Our Ref: **EG/35/12/**
Your Ref:

Town & Country Planning Act 1990 (as amended)
Town and Country Planning (Development Management Procedure) (England) Order 2010 (as amended)
Application for Full Planning Permission

Development Retention of horse-box hire business, mobile home, office/staffroom and an area of hardstanding.
Location Longreach Eastergate Lane Eastergate

TITLE	SITE PLAN
ADDRESS	LONGREACH EASTENGATE LANE PO20 3SS
SCALE:	1:200

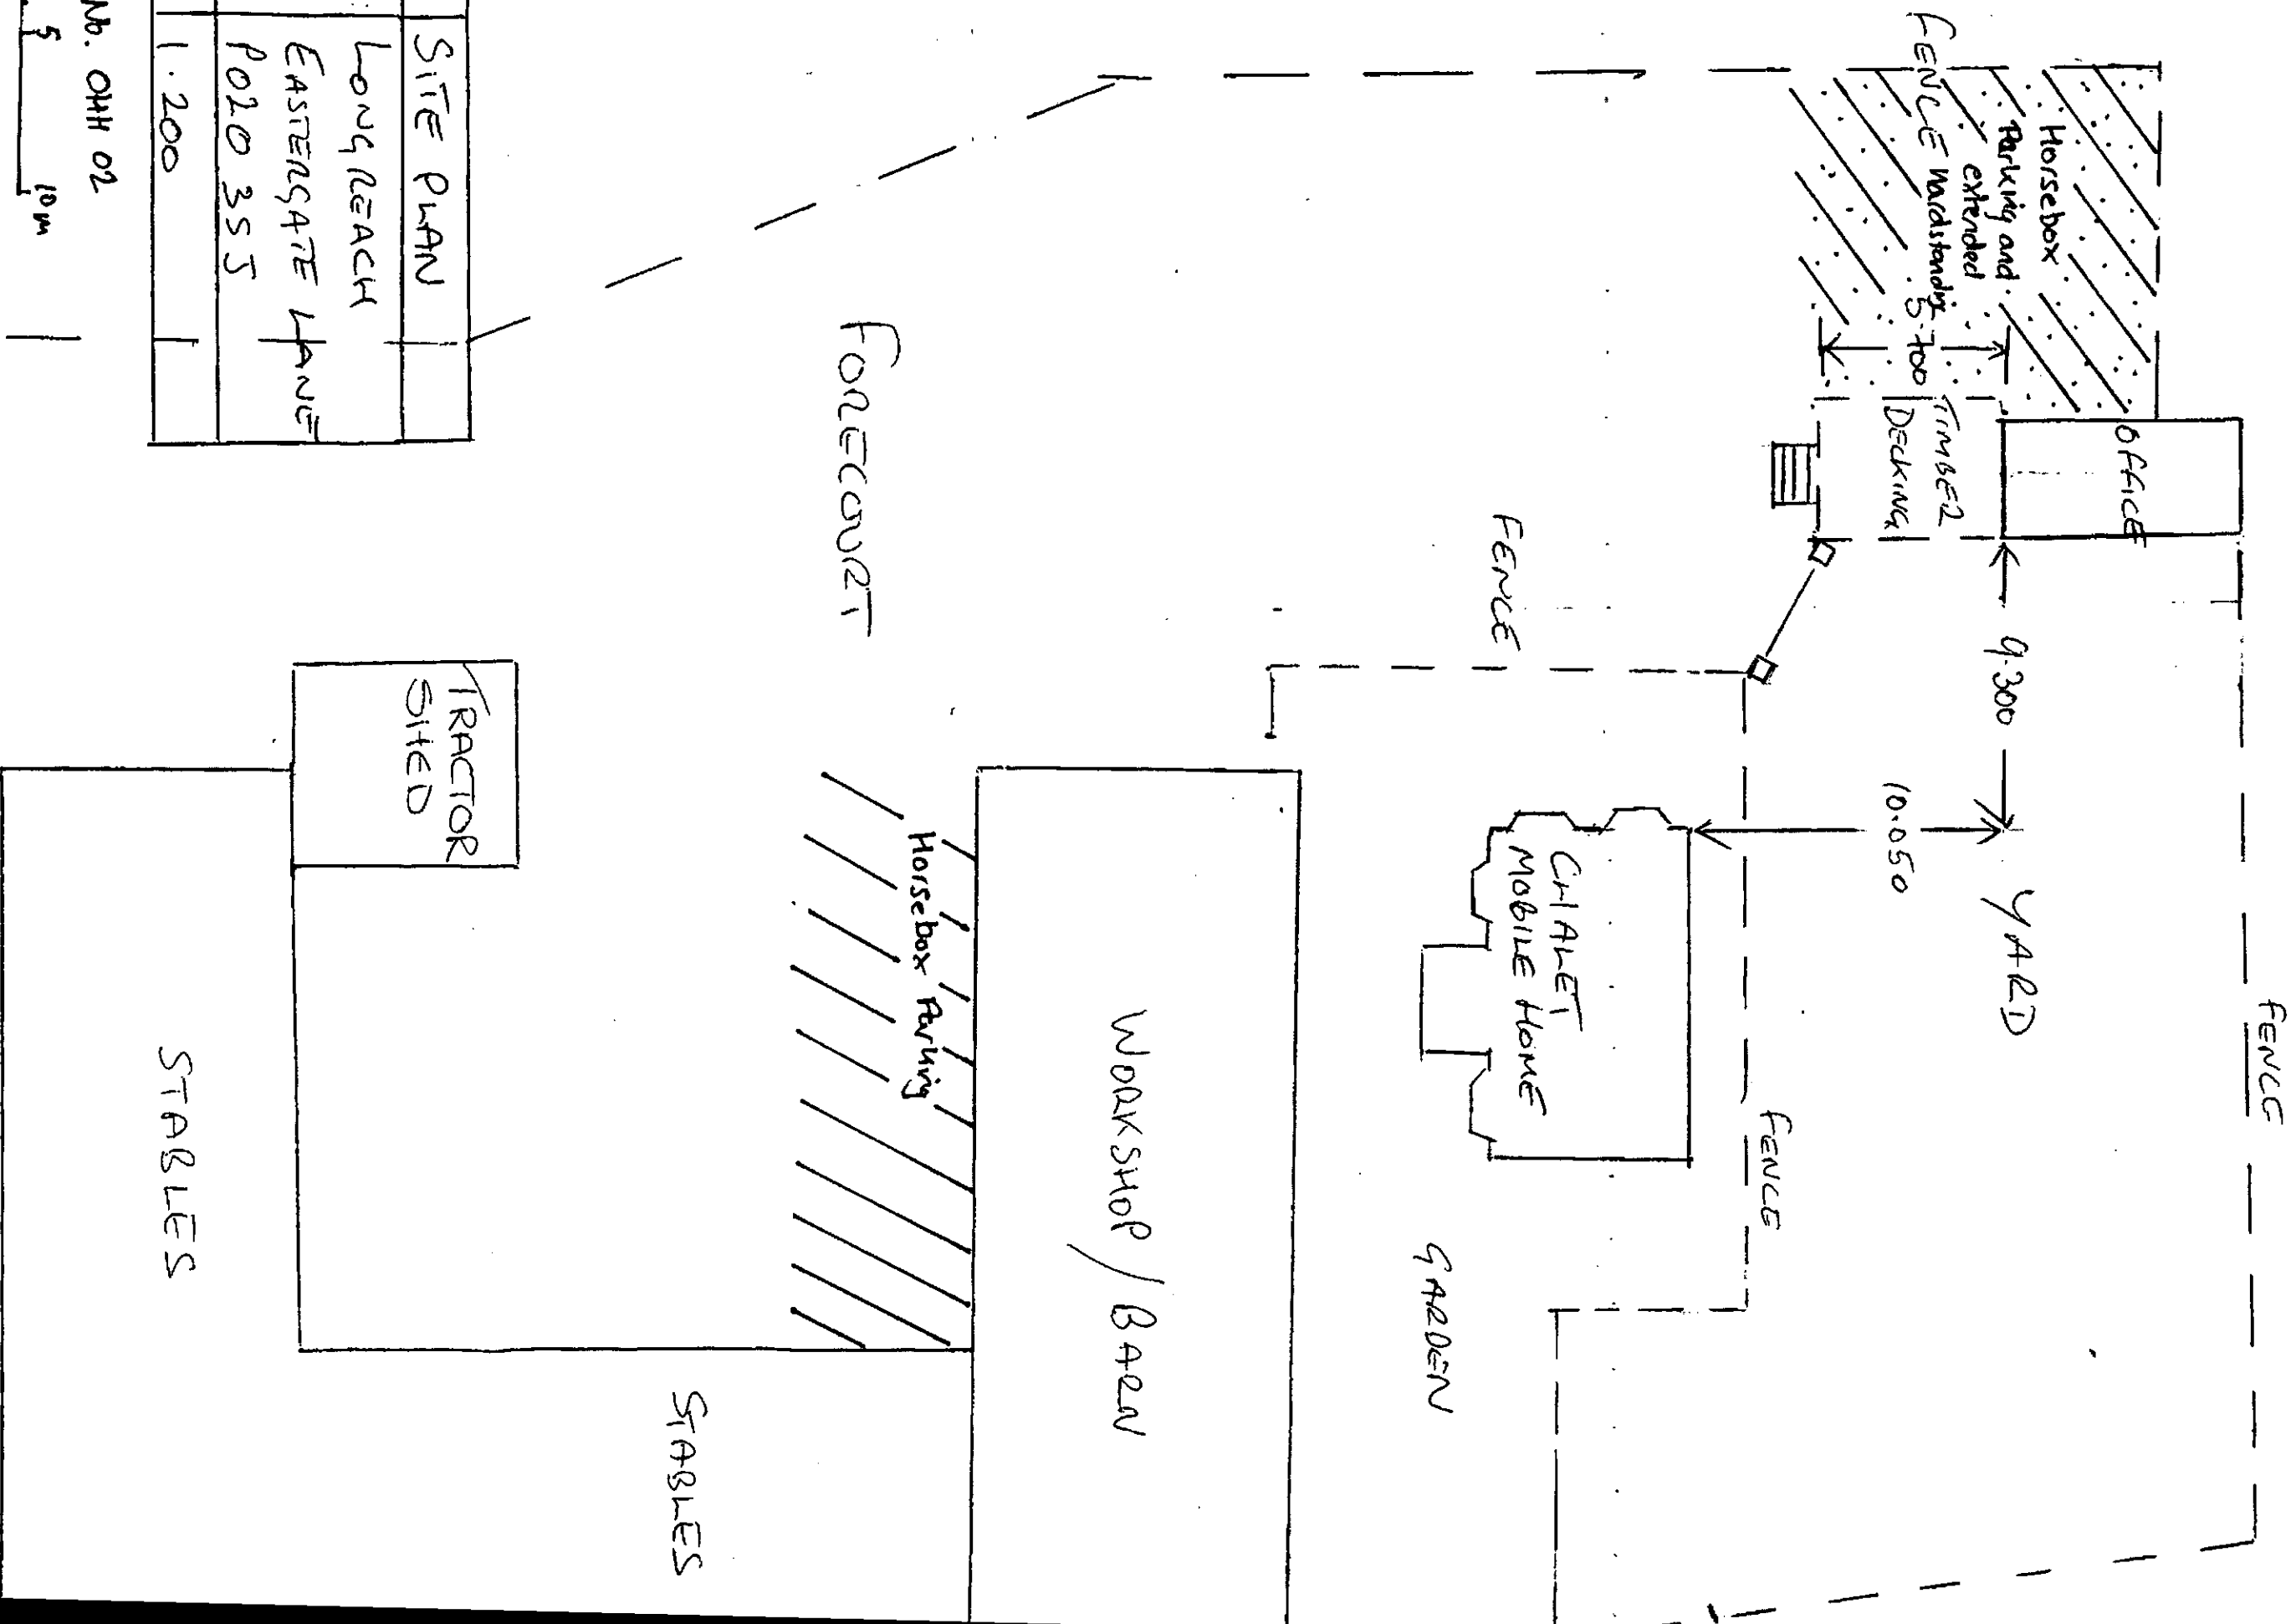
← I require 1 electronic or 3 paper copies of a block/site plan in accordance with the guidance notes available on our website detailed below (click on National List). Also, please show the decking for the office, the layout of the siting/parking of storage boxes. - *1 named road needed*

OFFICE ELEVATIONS

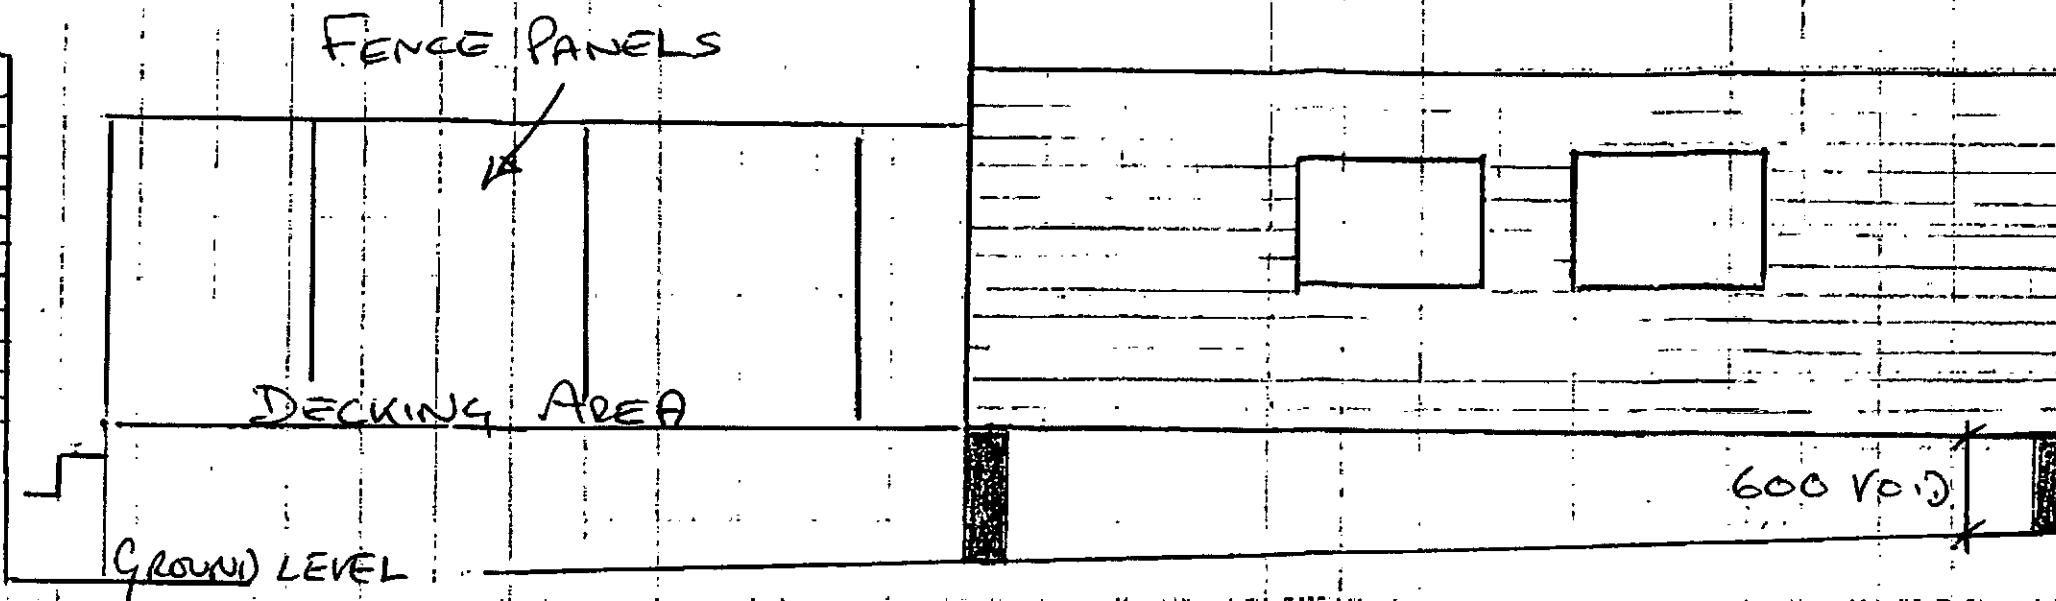
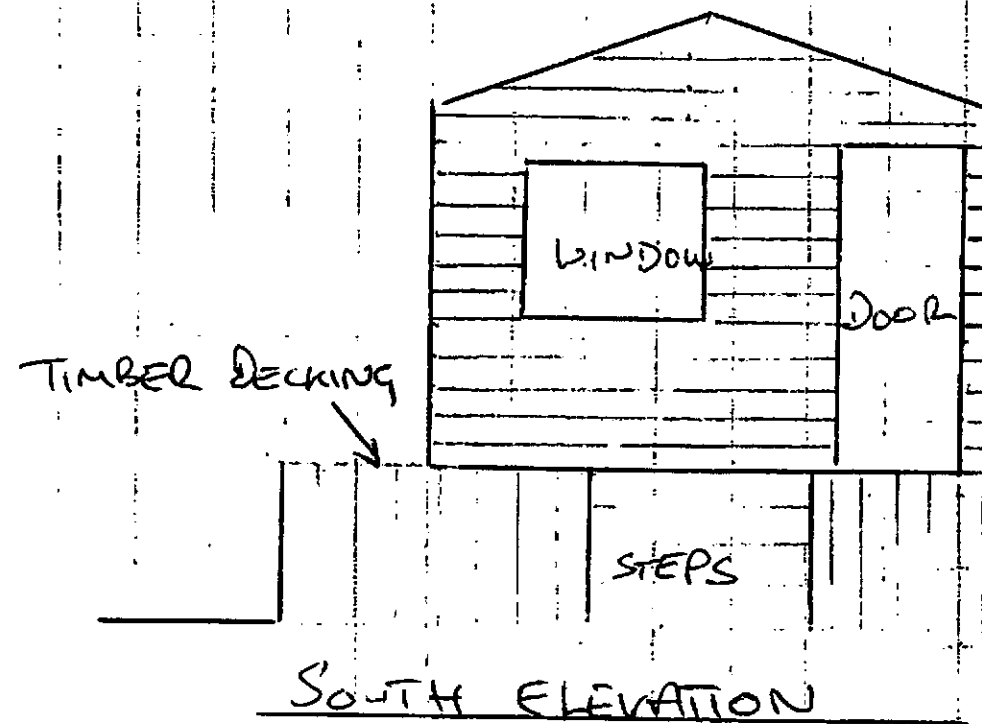
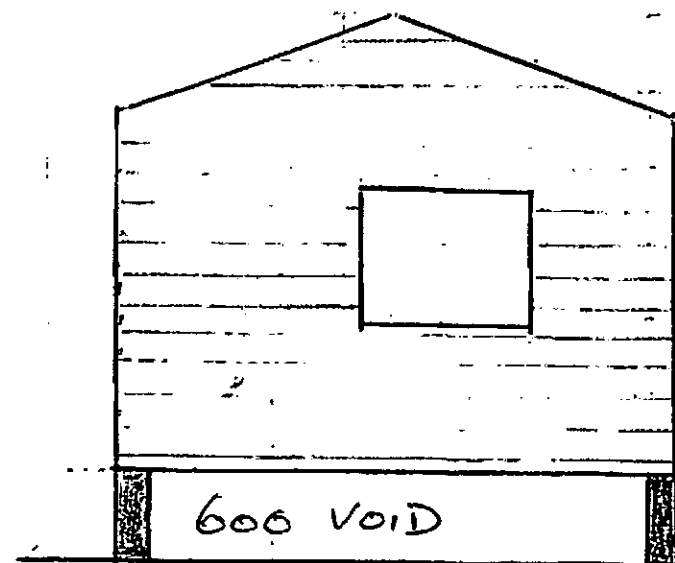
↑ Please provide 1 electronic or 3 paper copies of ~~existing and proposed~~ *single* floor plans for the mobile home and the staff/office room at a scale of 1:50 in accordance with the guidance notes available on our website detailed below (click on National List). *2 more elevations needed, floor plans don't cover*

↑ Please provide 1 electronic or 3 paper copies of existing and proposed elevations for the mobile home and the office/staff room in accordance with the guidance notes available on our website detailed below (click on National List). ✓

Site Location Plan

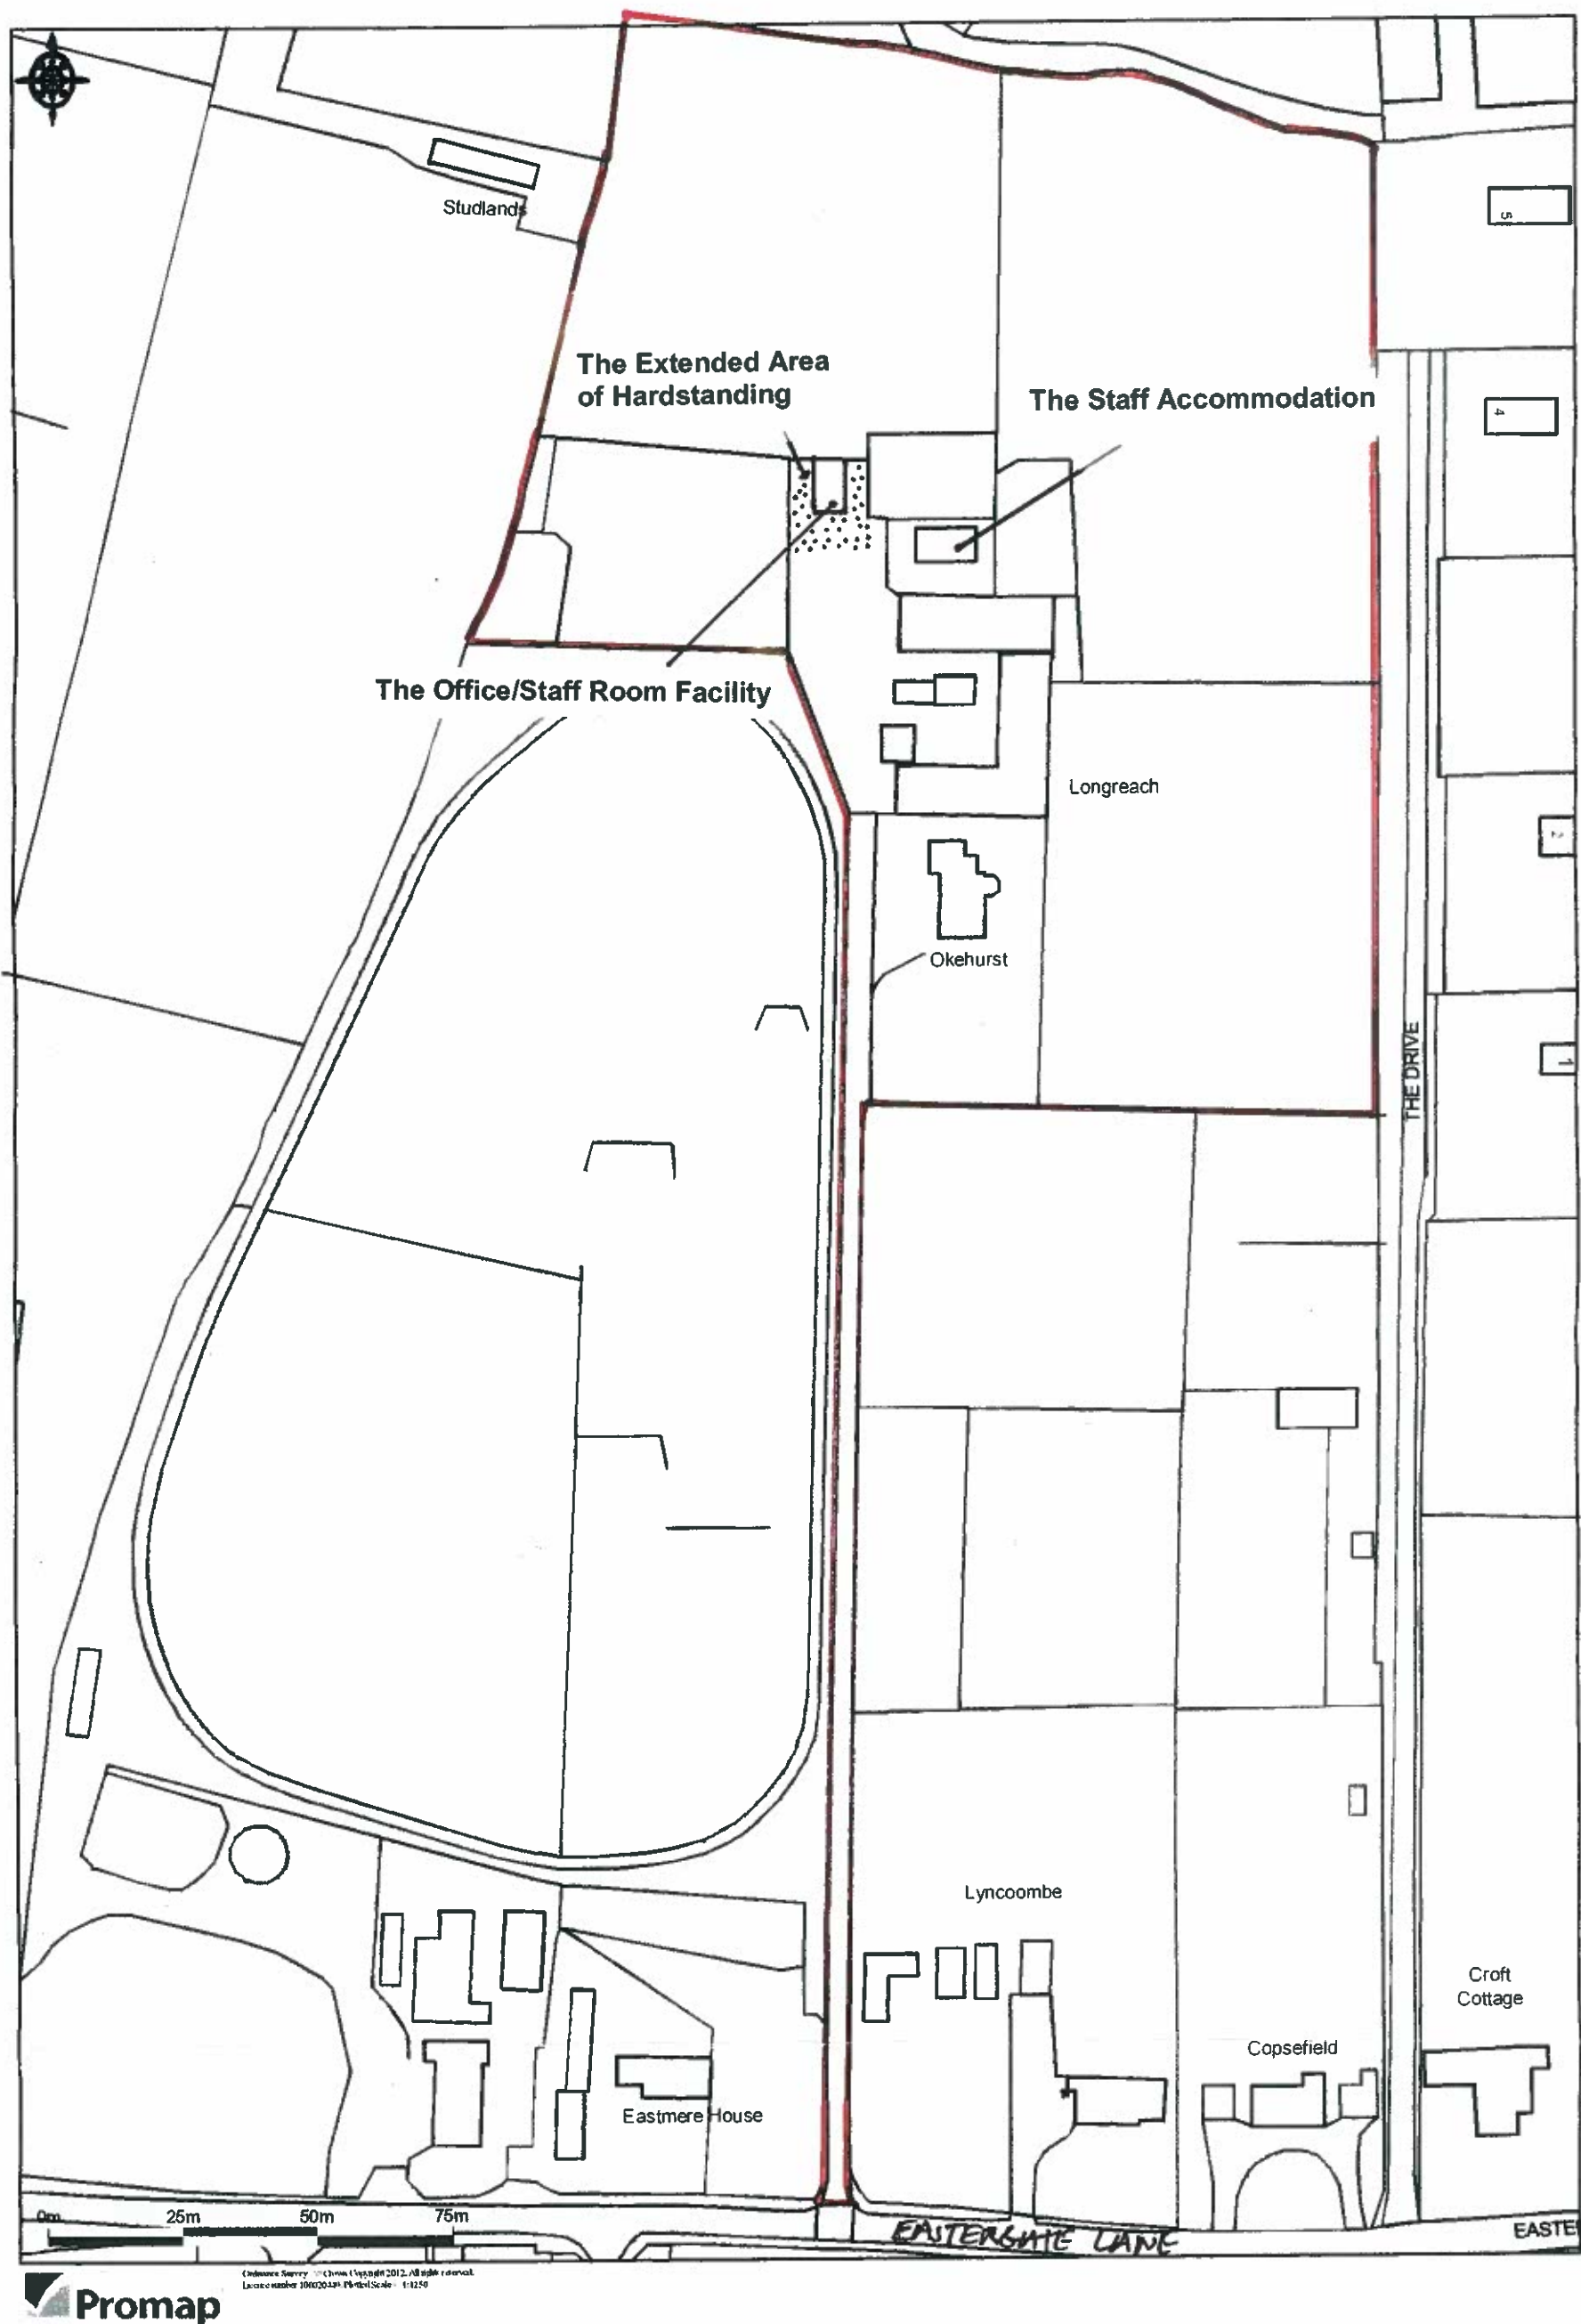
I require 1 electronic or 3 paper copies of a location plan in accordance with the guidance notes available on our website detailed below (click on National List). Please provide another named road. ✓

ROOF PLAN SCALE 1:100

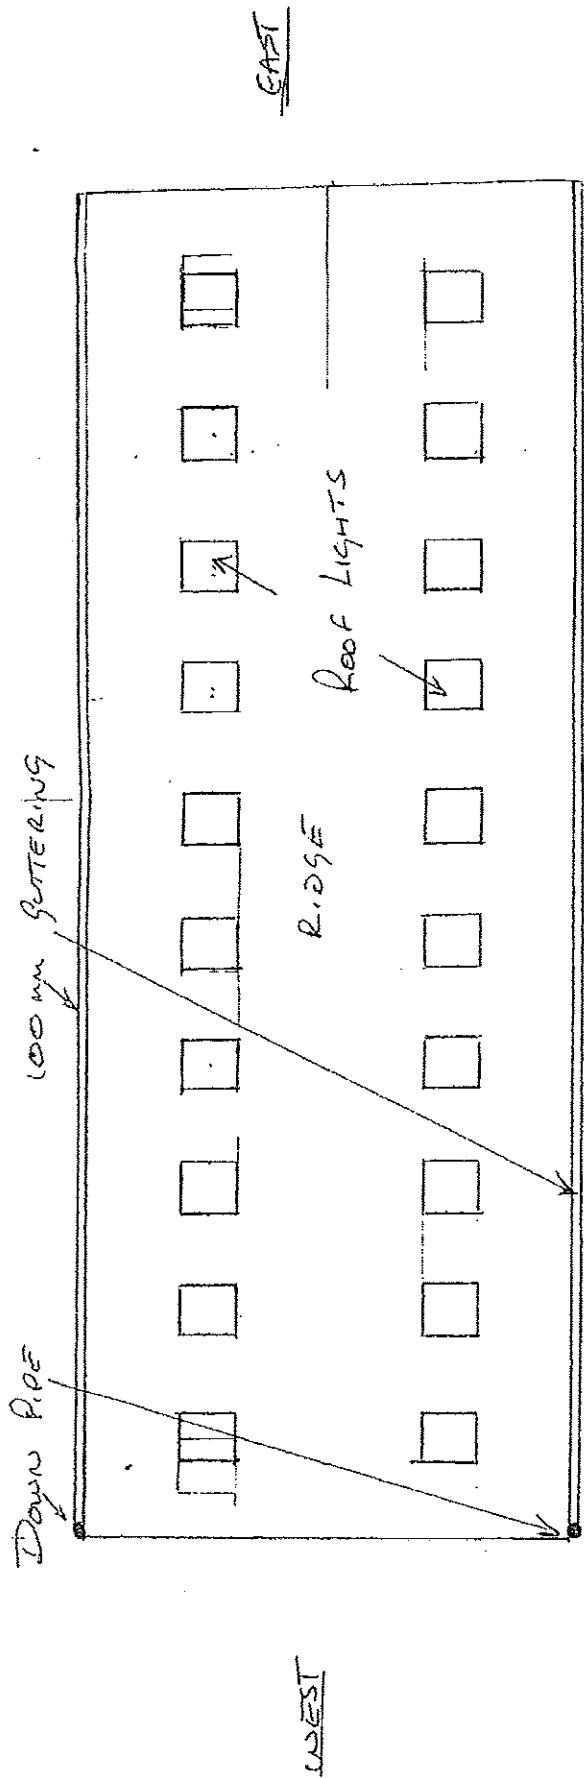
⚡ Please submit 1 electronic or 3 paper copies of existing and proposed roof plan for the mobile home and the office/staff room in accordance with guidance notes available on our website detailed below (click on National List).
